From
THE MEMBER-SECRETARY,
Madras Metropolitan
Development Authority,
No.8, Gandhi-Irwin Road,
Madras-600 008.

Letter No. A/17325/94

Sub: MMDA - Planning permission -
Construction of ^{G+1F} residential/commercial
building at Plot ~~Door~~ No. 176, Chowdary Nagar 16th St,
in S.No. 165/3 of Valasaravakkam
village - Approved - Regarding.

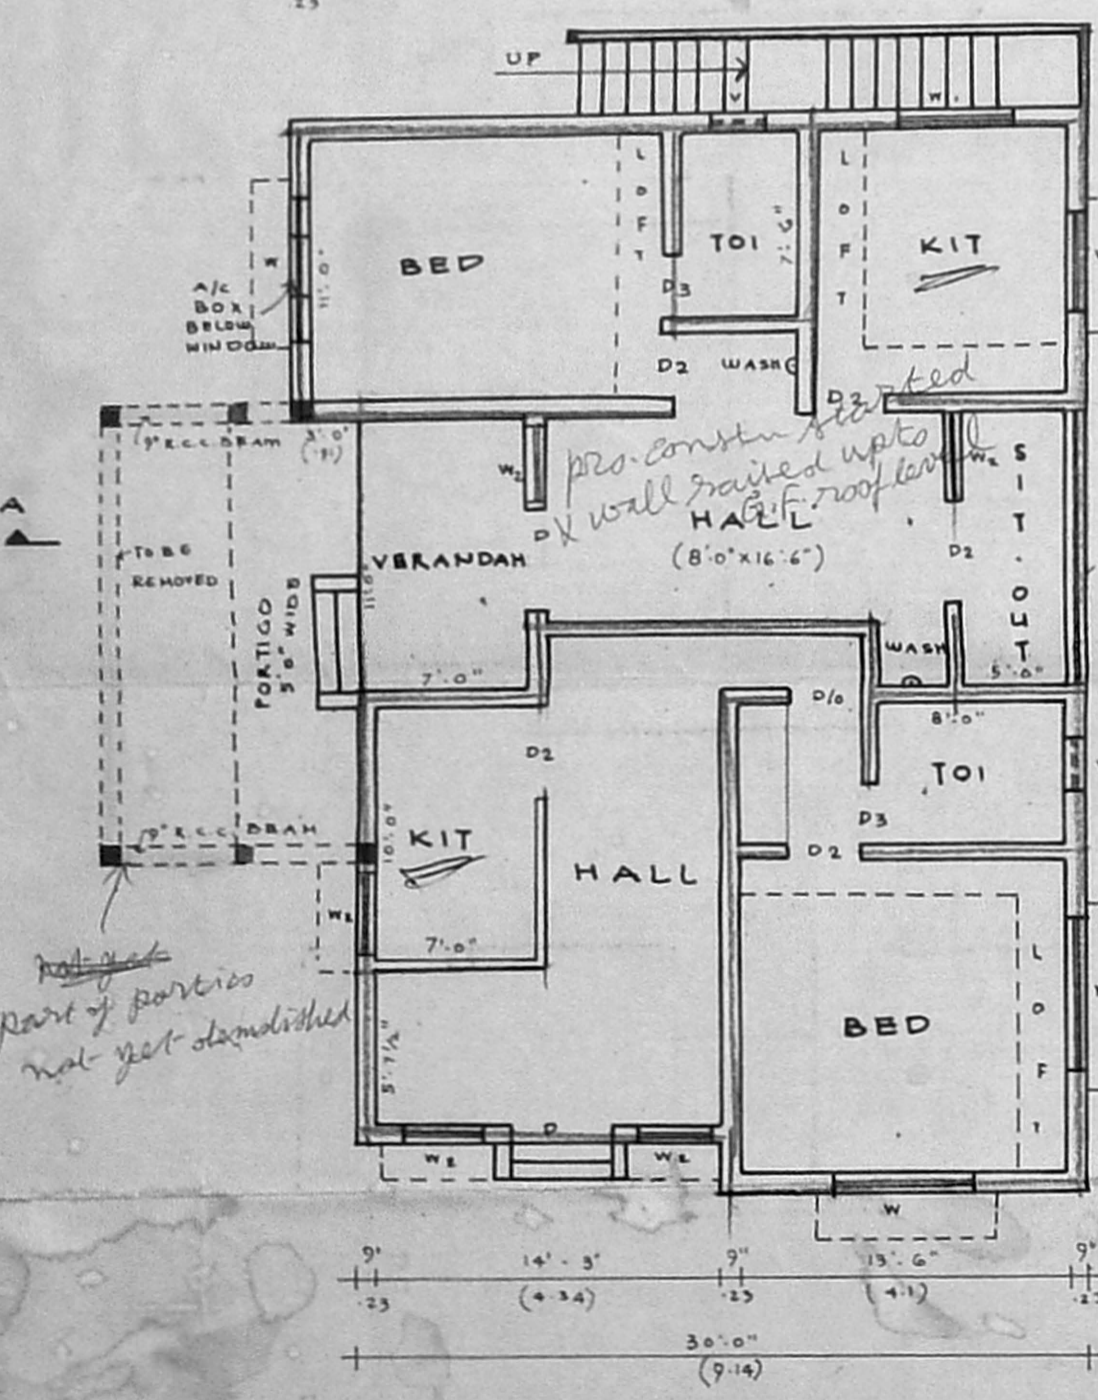
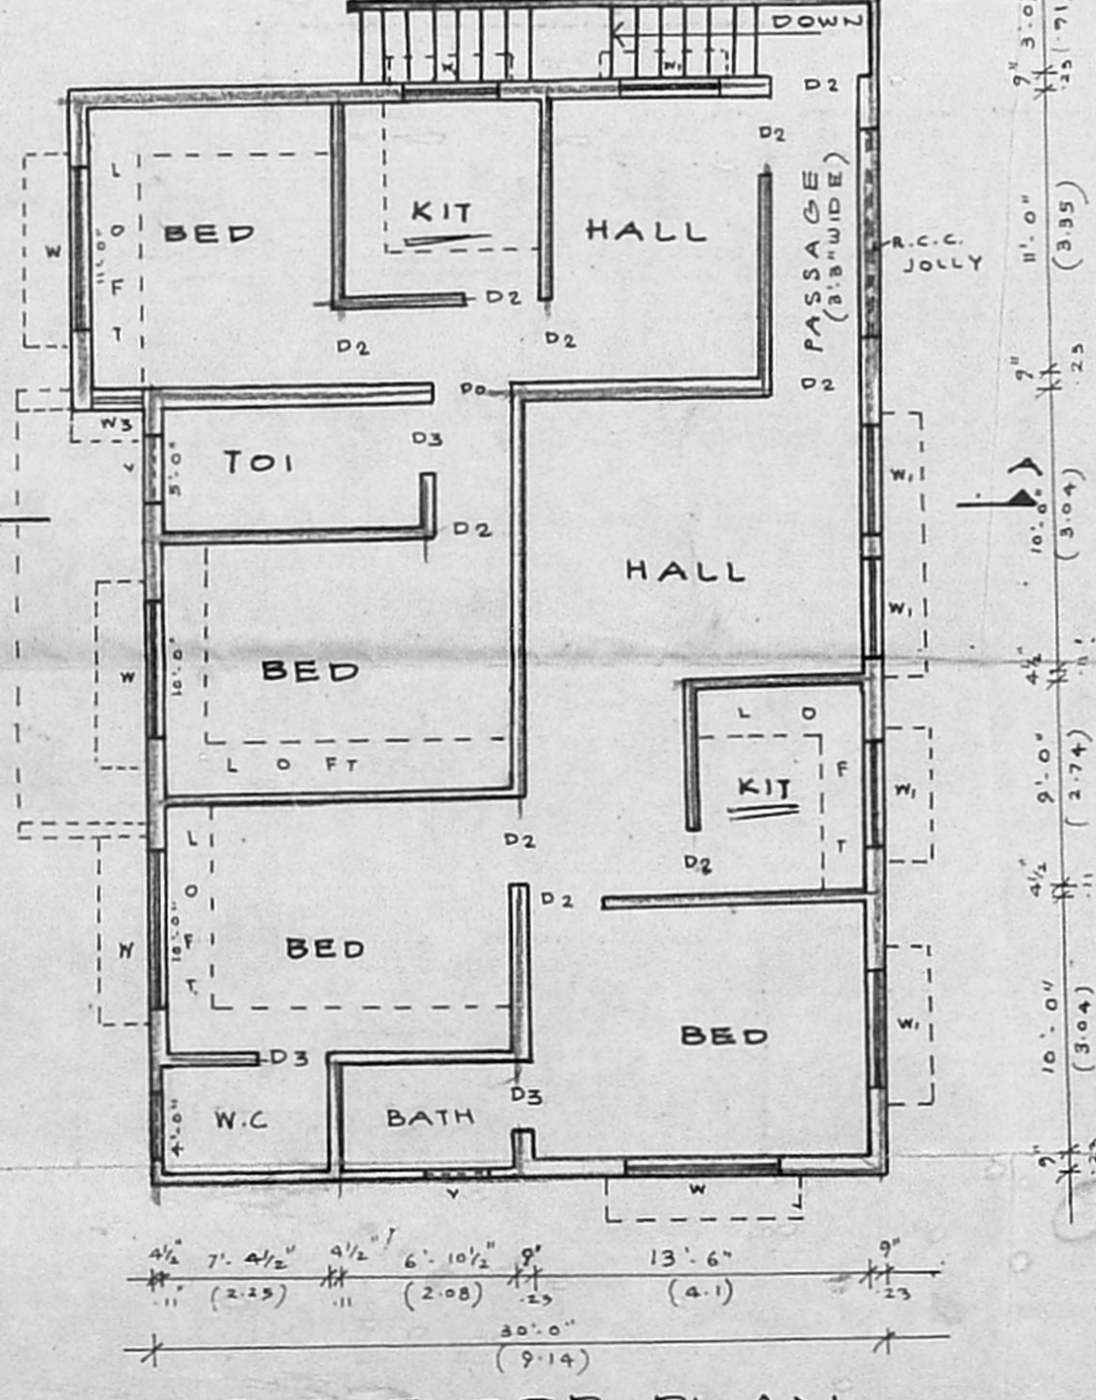
You are requested to release the plans after verifying the portion of staircase landing abutting the neighbour's compound wall is removed.
Yours faithfully,
